**CITY OF ALBUQUERQUE  
PLANNING DEPARTMENT  
August 26, 2015  
DRB Comments**

**PROJECT # 1010576**

**APPLICATION # 15-70291**

**RE: Lots 3 & 4, Block 20, Tr. 3 Unit 1, North Albuquerque Acres**

PRELIMINARY PLAT OF
HOLLY ESTATES SUBDIVISION
SITUATE WITHIN
PROJECTED SECTION 16
T.11N., R.4E., N.M.P.M.
ELENA GALLEGOS LAND GRANT
CITY OF ALBUQUERQUE
A REPLAT OF LOTS 3 THRU 6, BLOCK 6,
TRACT 3, UNIT 1, NORTH ALBUQUERQUE ACRES
APRIL 2016

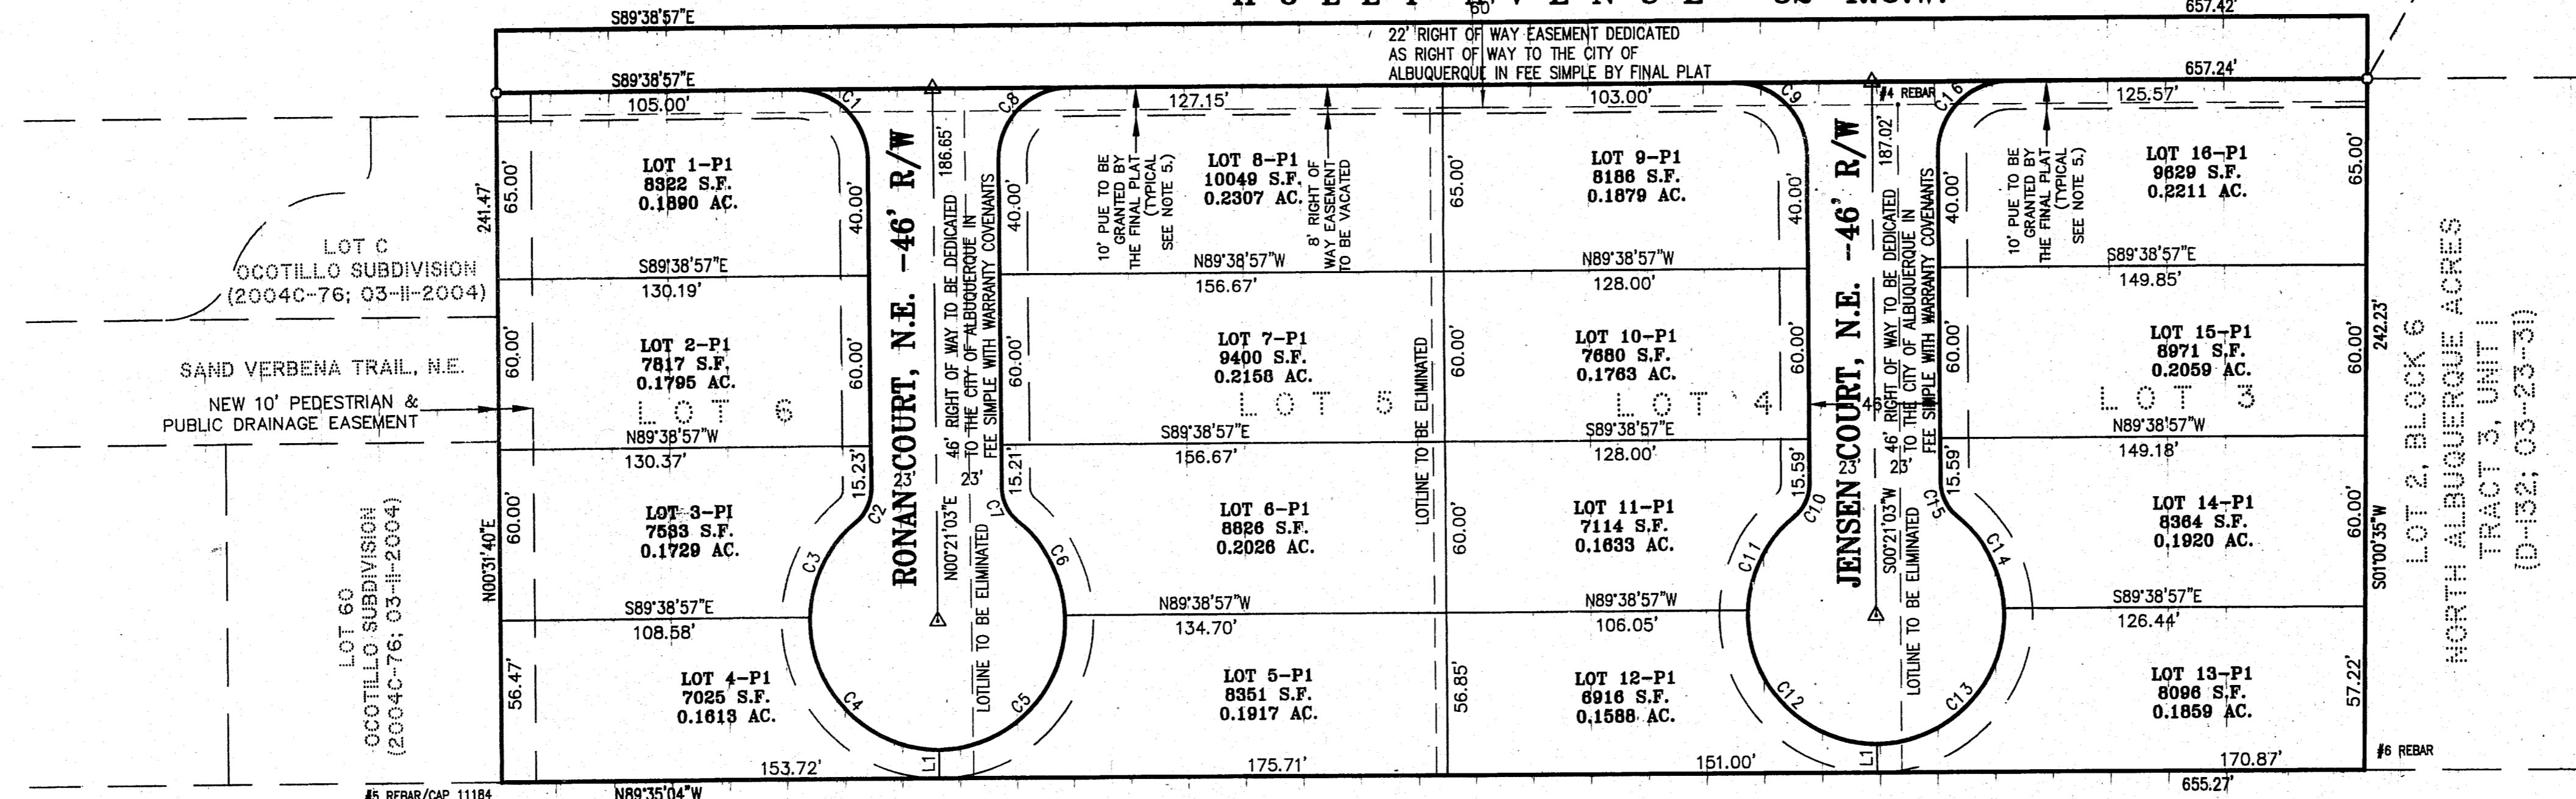
The R-D Open Space requirement of 2,400 sq ft per dwelling needs to be demonstrated.
